From: Grace Palmer <[REDACTED]>
Sent: 23 August 2021 15:57
To: Simon Davis
Cc: Lauren Wiltshire; Polly Murray
Subject: RE: Planning Re-Consultation on: BN/98/21/DOC
Attachments: 108.5009.751.A.pdf; 108.5009.519.pdf; 108.5009.551.D.pdf; 108.5009.520.pdf; 108.5009.504.C.pdf; 108.5009.502.C.pdf; 108.5009.503.D.pdf; 108.5009.505.B.pdf; 108.5009.552.pdf; 108.5009.506.C.pdf; 108.5009MMS2 Land a Fontwell Avenue, Eastergate -SuDS Management and Maintenance Plan (BOUND) (1).pdf; 108.5009.500.pdf; 16695 Letter Report_ISSUE (1).pdf; 210816_DD504DS01_Drawing Issue Sheet.pdf; DD504L03B-Detailed Planting Plan 3 of 8.pdf; DD504L04B-Detailed Planting Plan 4 of 8.pdf; DD504L07B-Detailed Planting Plan 7 of 8.pdf; DD504L09B_Planting Details.pdf; DD504L08B-Detailed Planting Plan 8 of 8.pdf

Engineers Comments Regarding Condition 10

Engineers Comments Regarding Condition 11

DRAWING TITLE:
Detailed Planting Plan
2 of 8

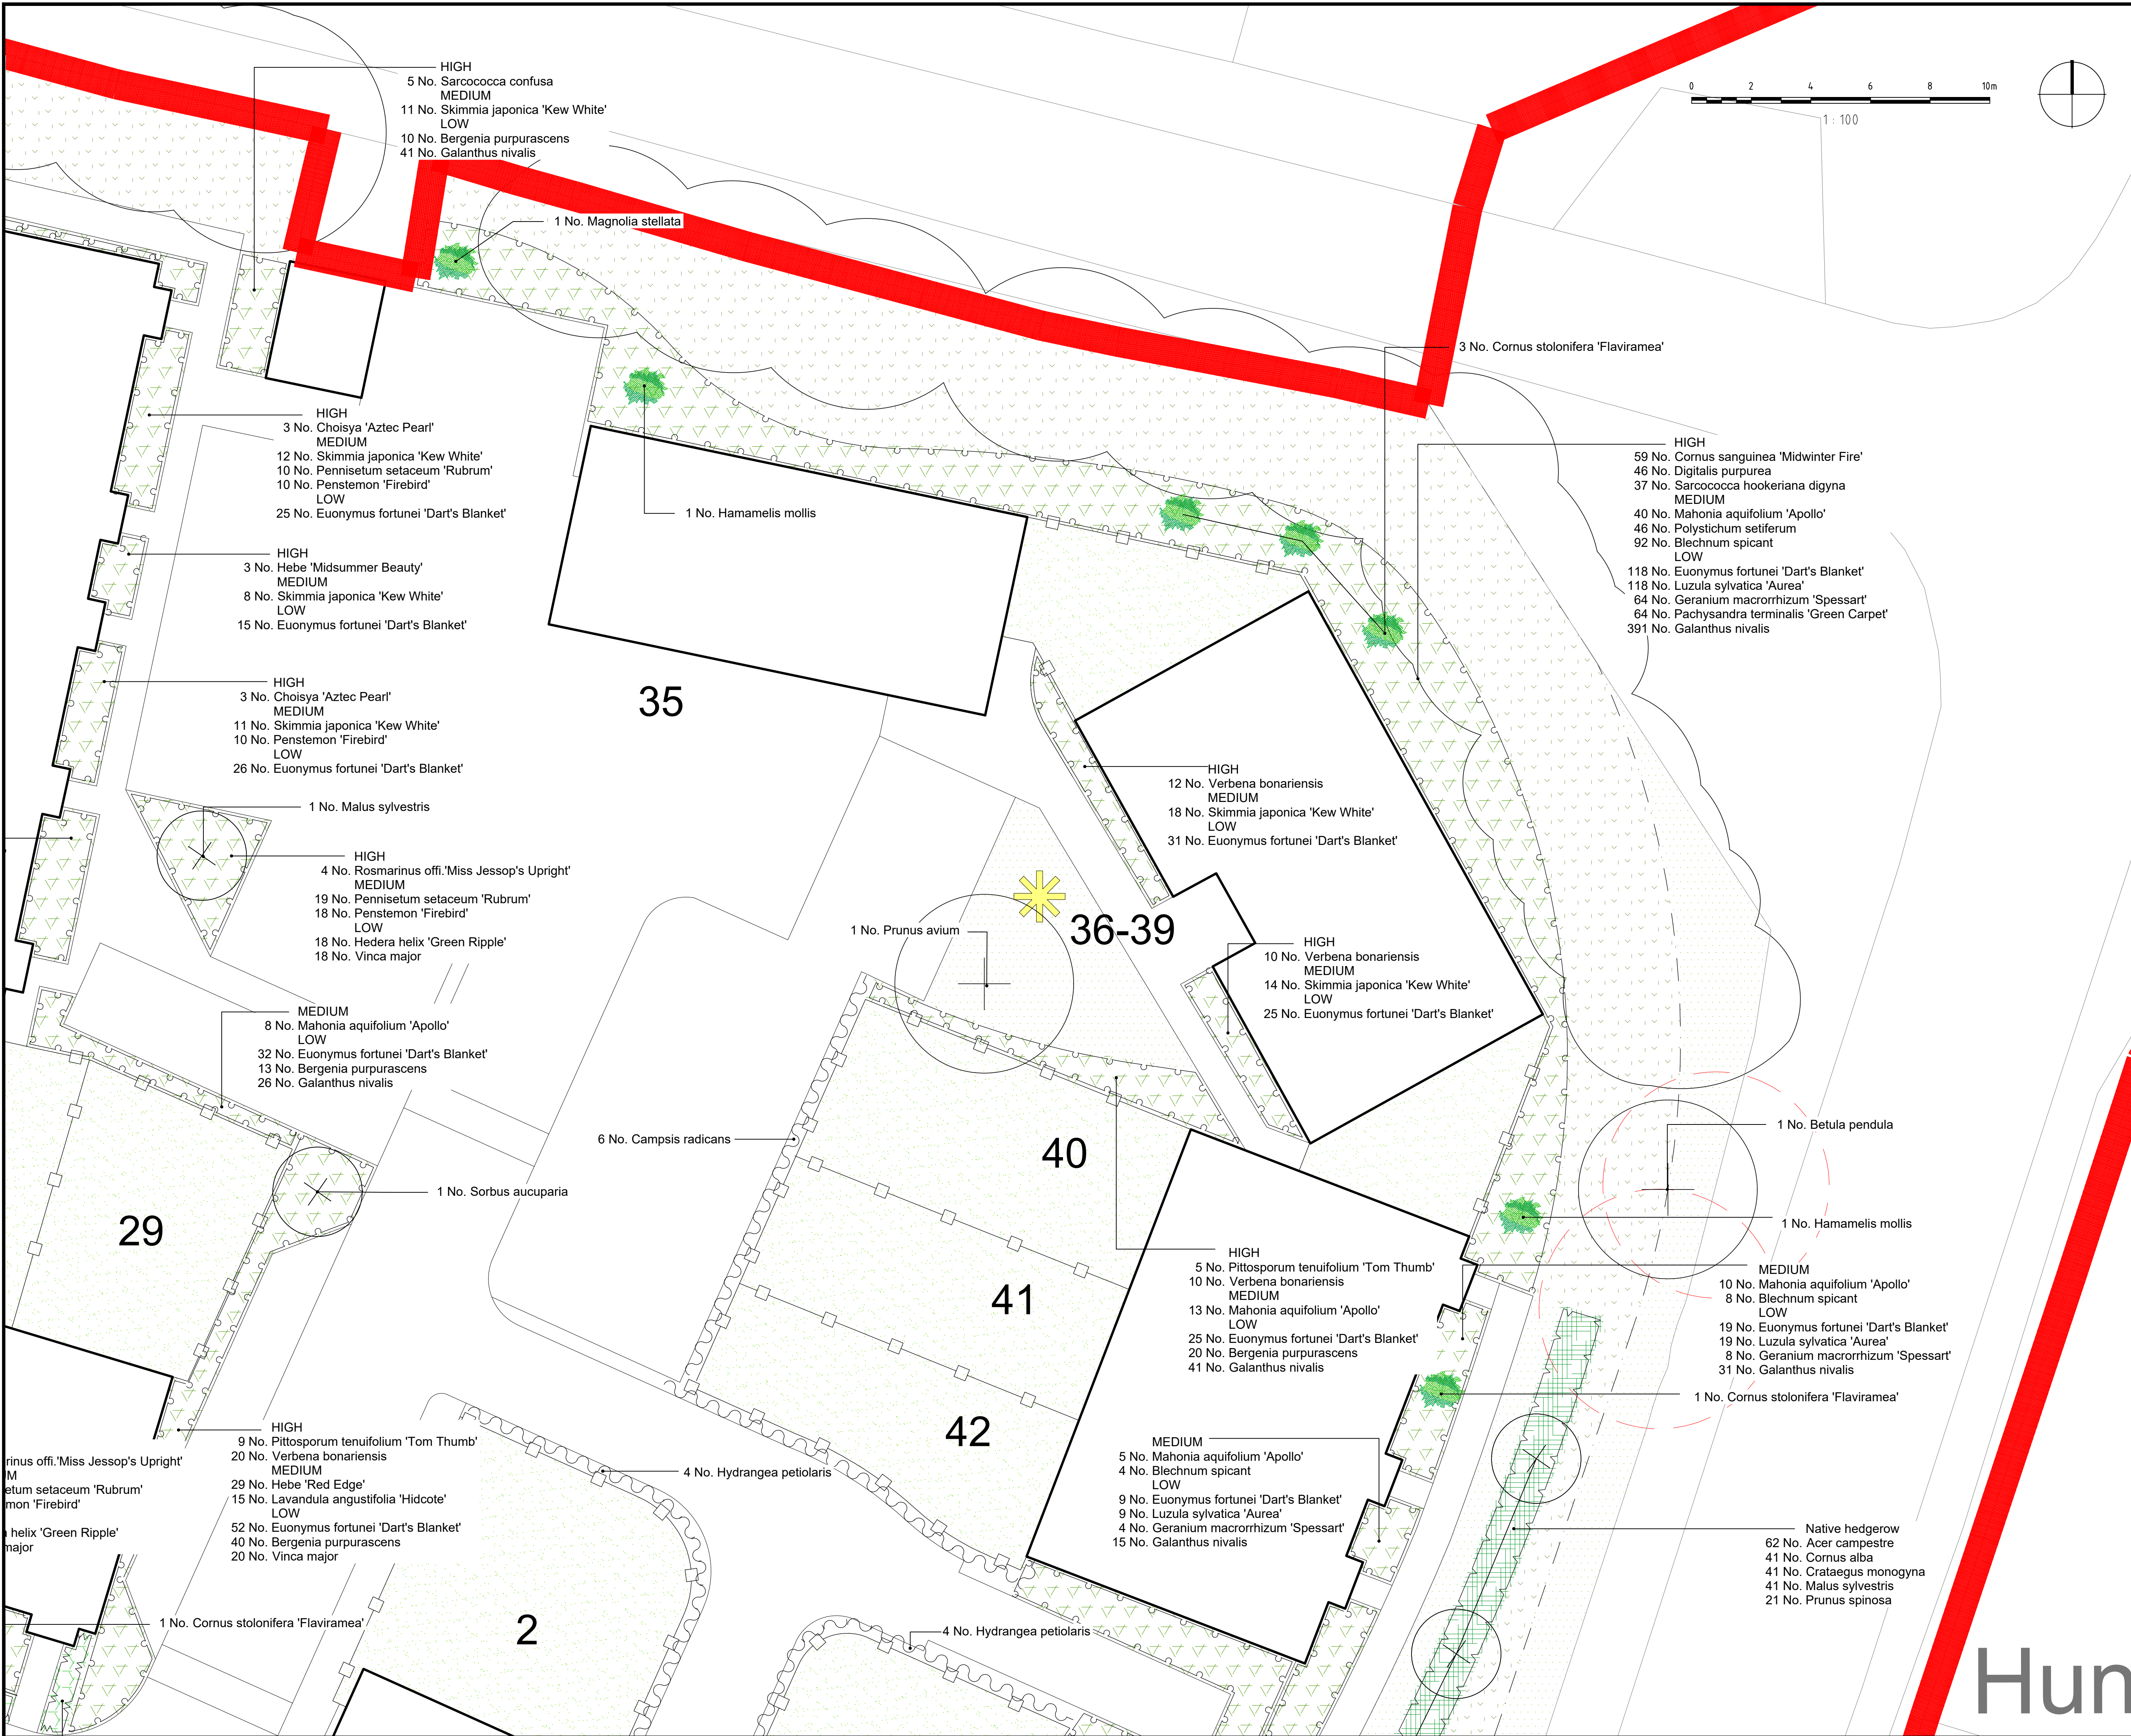
- There is significant conflict between the proposed landscaping plans and the proposed drainage. This must be resolved so that trees are not proposed over pipes or crates.

- ✧ There is significant conflict between the proposed landscaping plans and the proposed drainage. This must be resolved so that trees are not proposed over pipes or crates. Updated landscape plans attached, resolving clashes with proposed trees and soakage crates this has been overlaid by engineer to check also.
